From: Michael Eastham
Sent: 04 April 2018 13:41
To: Tim Townsend
Cc: SU Local Development; Planning.Responses
Subject: FW: LU/426/17/DOC - Porposed acoustic barrier - Fitzalan Relief Road - WSCC Highways response dated 14th March 2018

I have received the following response from Rob Clark regarding LU/426/17/DOC relating to the acoustic barrier at the Fitzalan Link Road.

FL.1

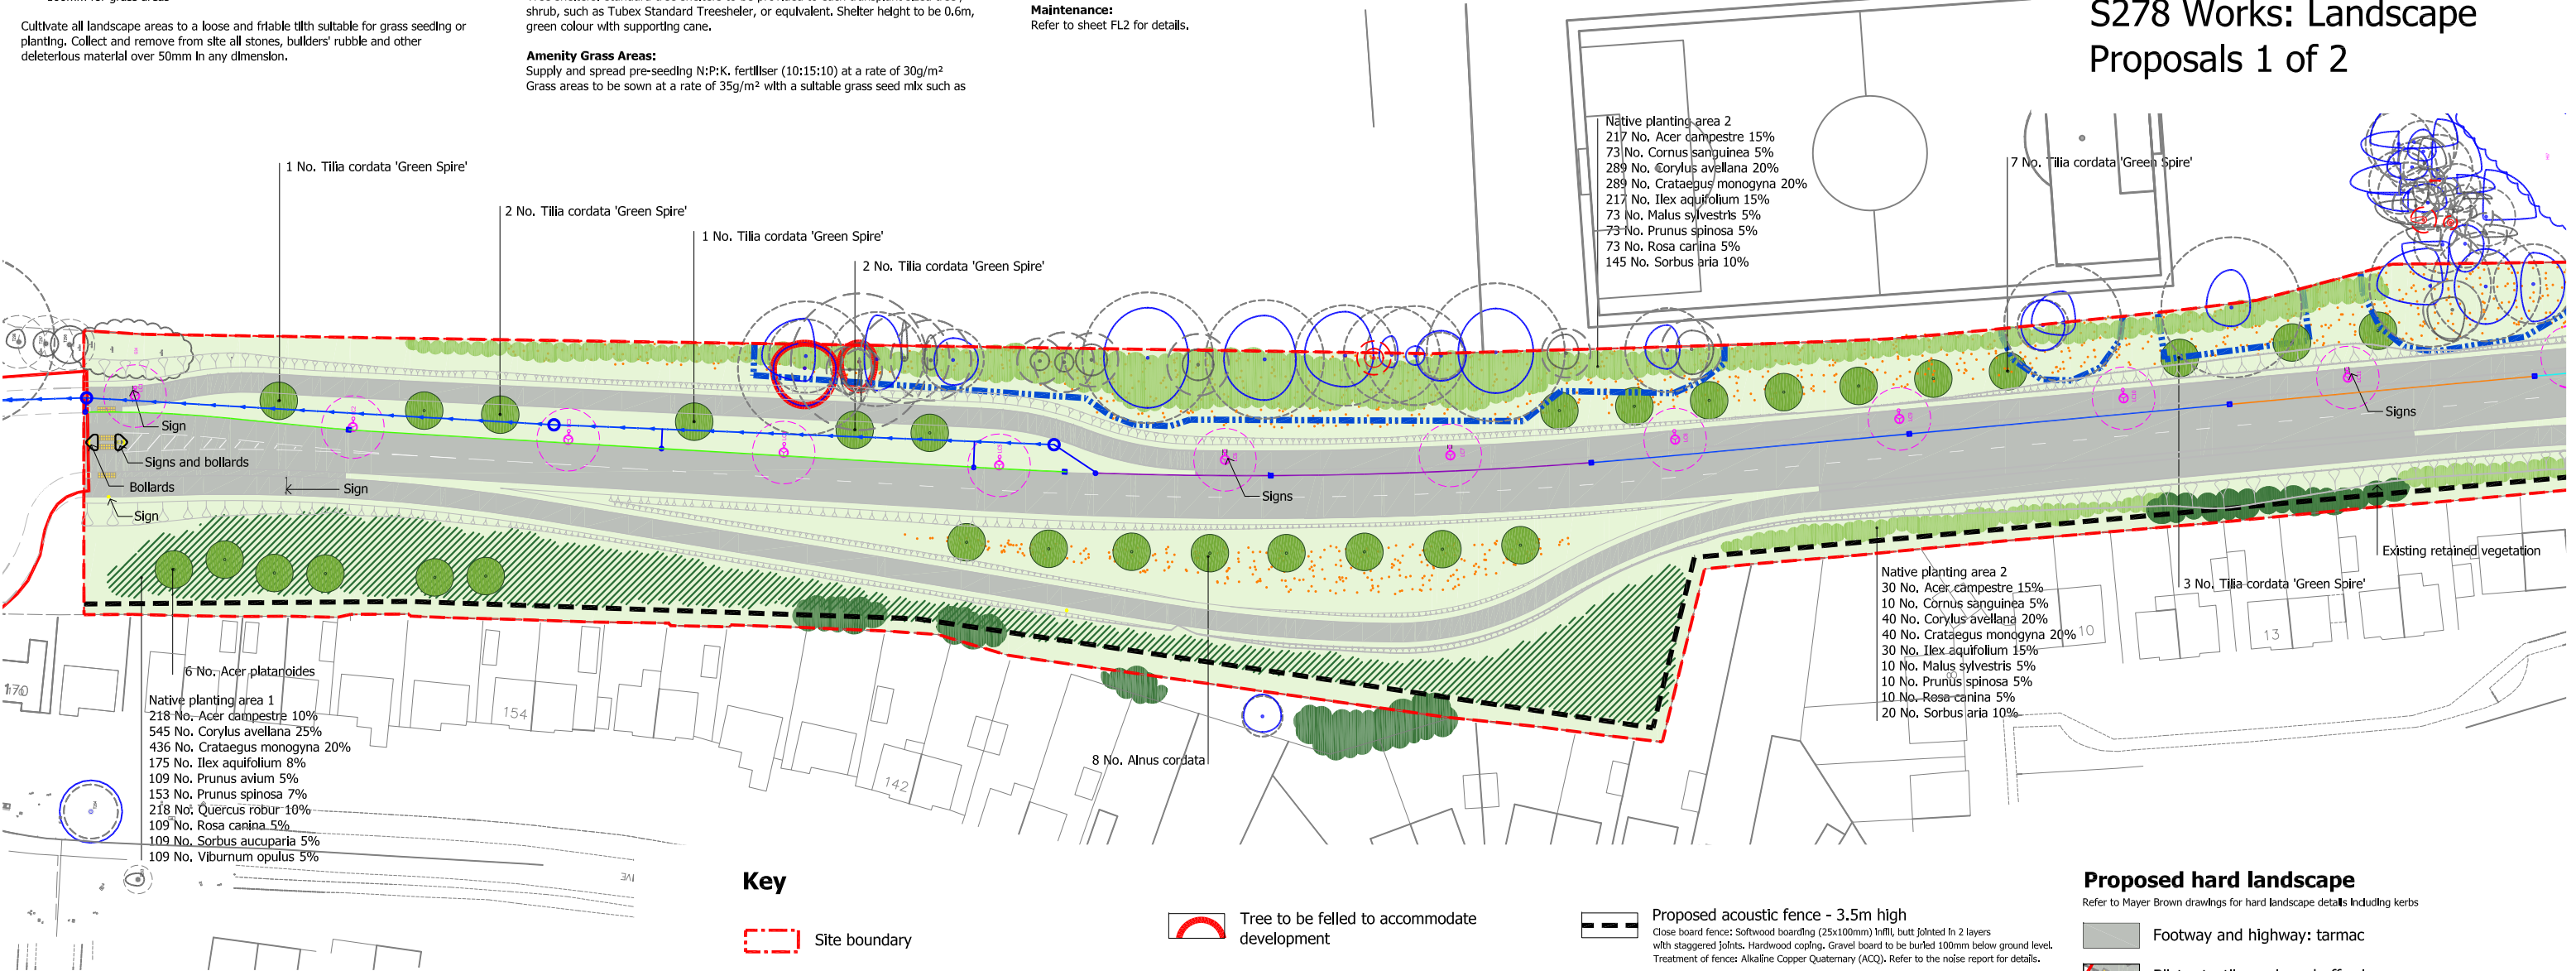
12. Land to rear of 22 to 30 Highdown Drive (brown area): It is not clear from the drawing whether some of this area is included within the site boundary. Access will be required for maintenance of the land. *Applicant to respond further. Reply from applicant is that this is to be checked. Further reply awaited.*
13. The detailed design for the academy roundabout shows the central island as being hard paved with no planting. *Please provide comments from the highway designer setting out whether it is appropriate to accommodate planting here. Applicant has said that it is for the engineer to respond. Further reply awaited.*

On point 14, we are restricted by visibility splays on the roundabout. However, we can have low level planting (no more than 0.5m in height) and one tree (with narrow stem).

On point 12, the land to the rear of 22 and 30 is owned by the applicant and could be accessed via a maintenance gate.
